Ribble Valley Borough Council
Planning Section
Council Offices
Church Walk
Clitheroe
BB7 2RA

Planning Application No: 3/2026/0281

Proposal: Demolition of existing dwelling and erection of one replacement self-build dwelling with garage and associated garden curtilage, hard and soft landscaping, new access drive off Longsight Rd and the closure of the existing access.

Location: Bridgecroft, Longsight Road, Copster Green BB1 9EX

2 PROPOSED SITE PLAN - PLANNING
1: 500

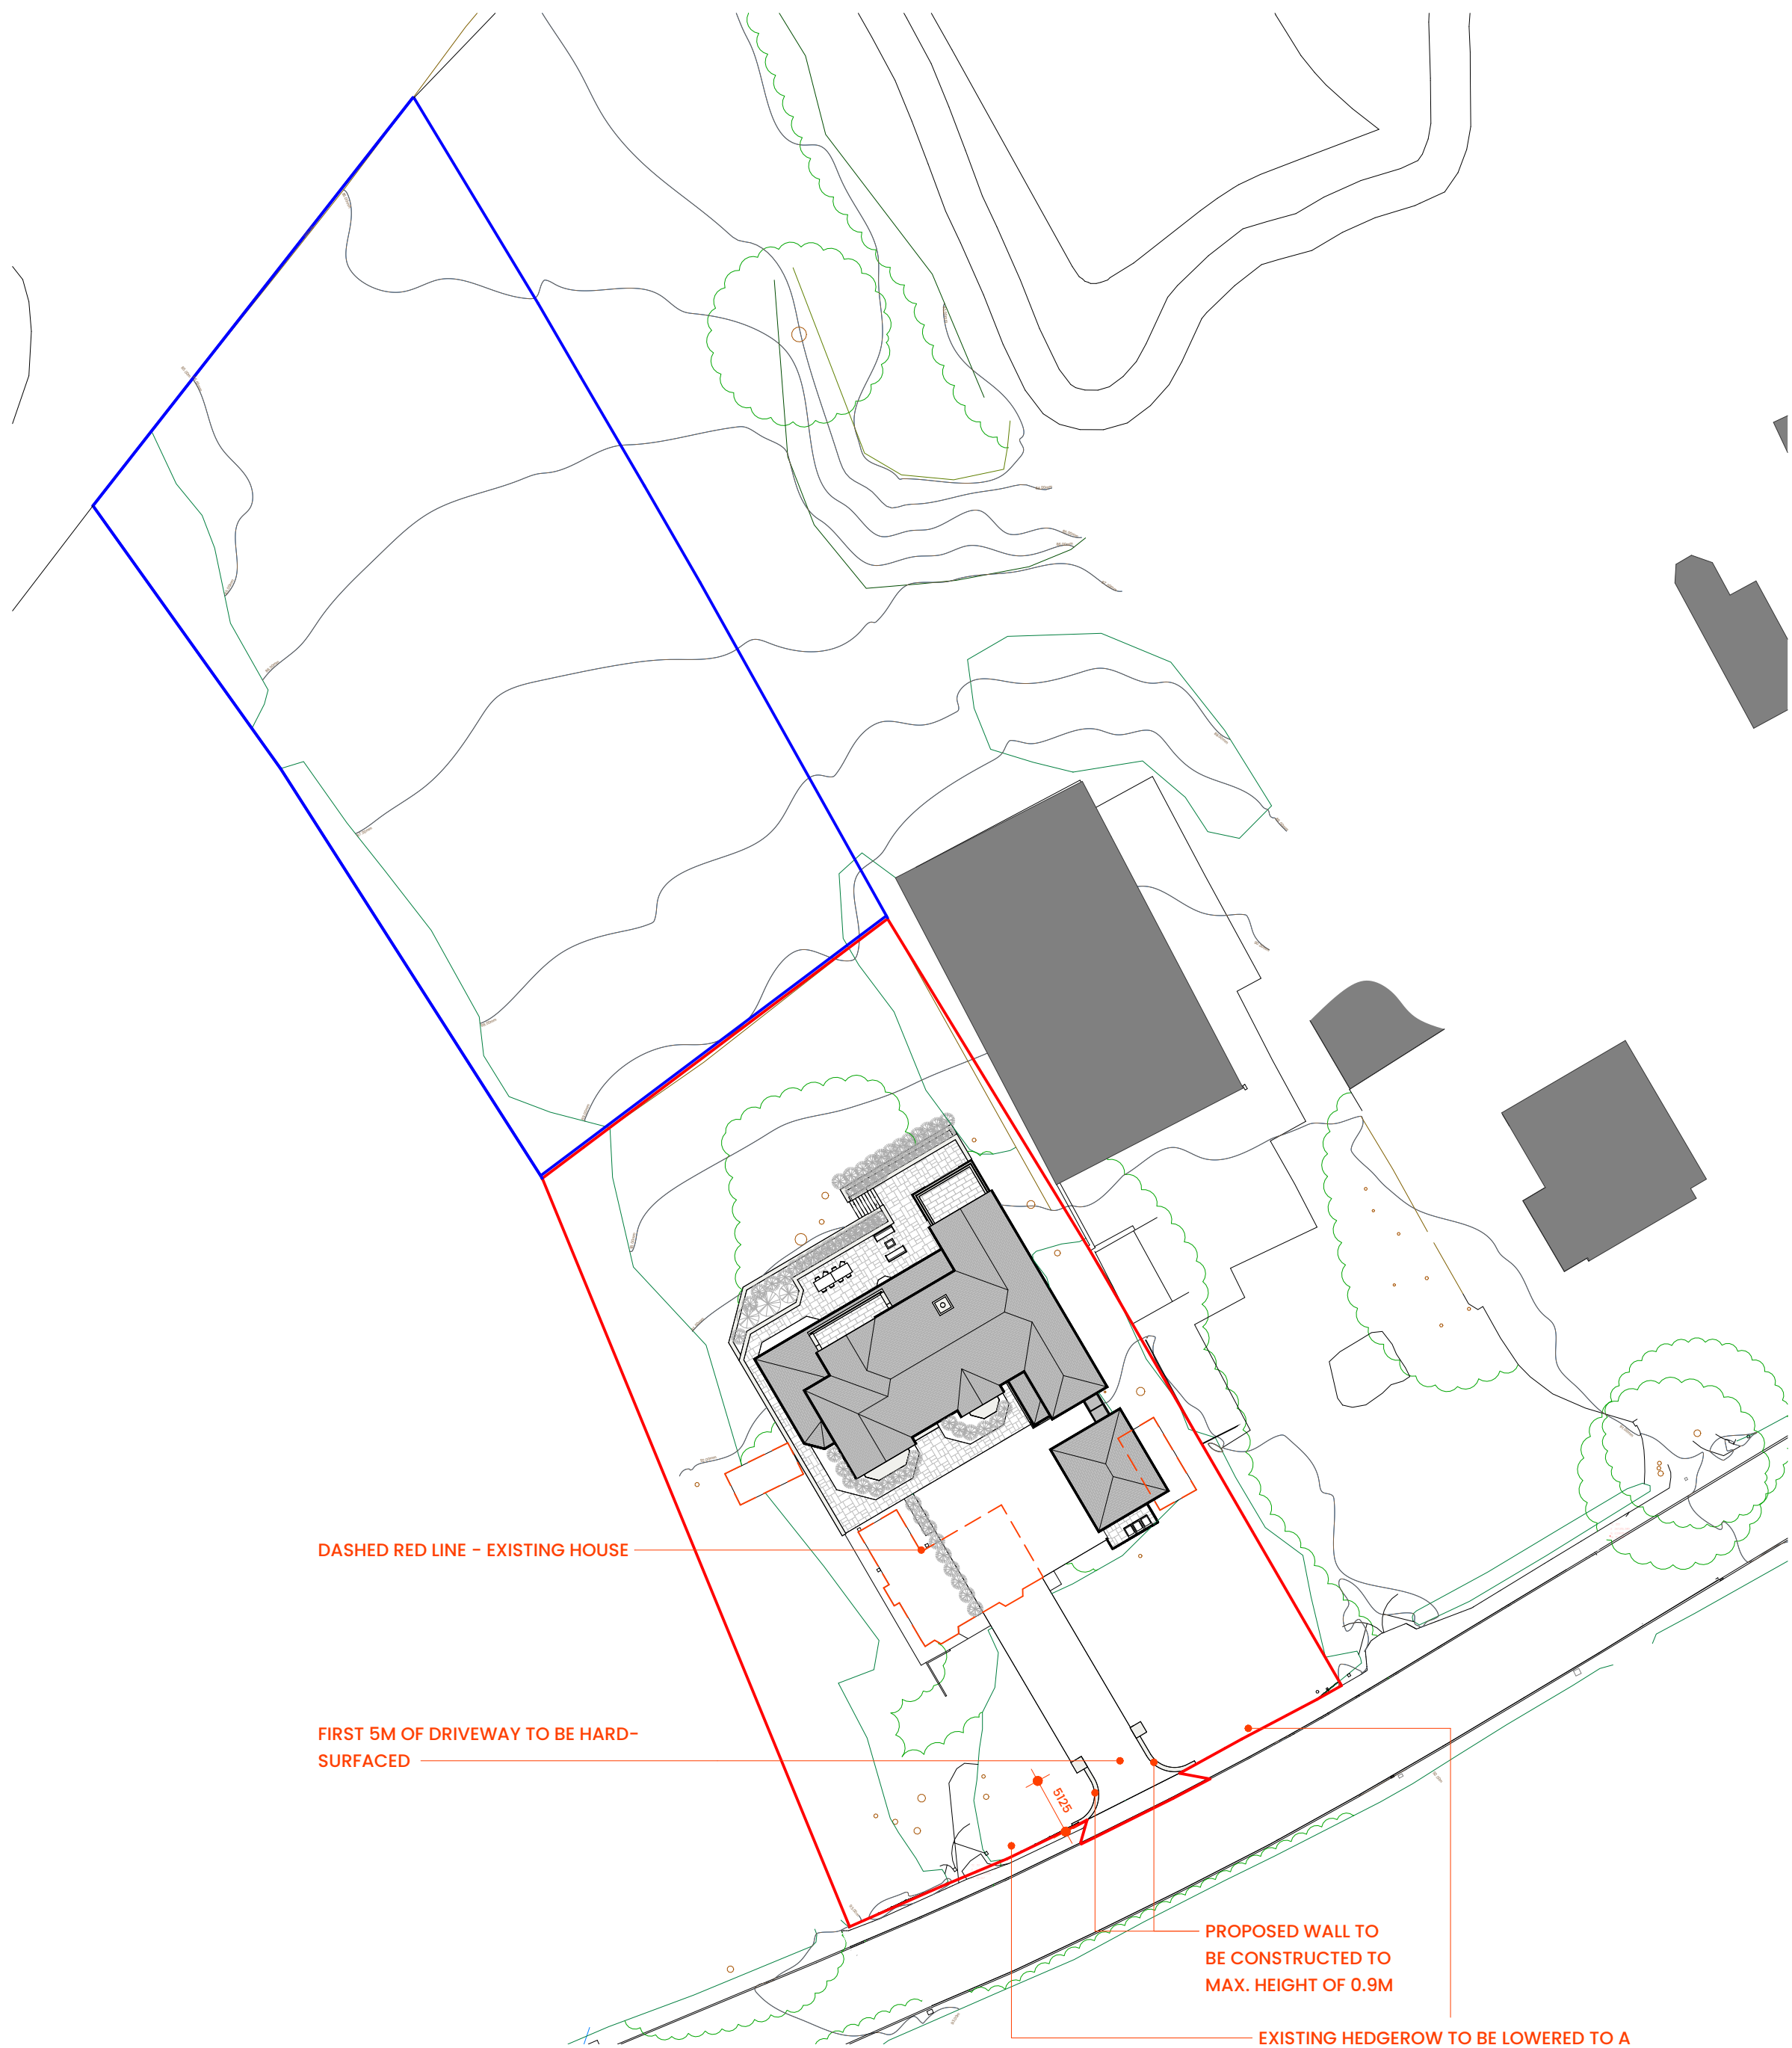
The proposed access has been widened to 5m for the first 5m from the back of the footway which should allow two vehicles to pass within the entrance and so prevent a vehicle from having to wait on Longsight Road. The highway authority now considers that the access layout shown on the Amended Proposed Site Plan (Drawing PL1.01B) is acceptable.

5. The proposed access from the site to shall be constructed to a minimum width of 5m and this width shall be maintained for a minimum distance of 5m measured back from the back edge of the footway. Reason: To enable vehicles to enter and leave the site in a safe manner without causing a hazard to other road users.
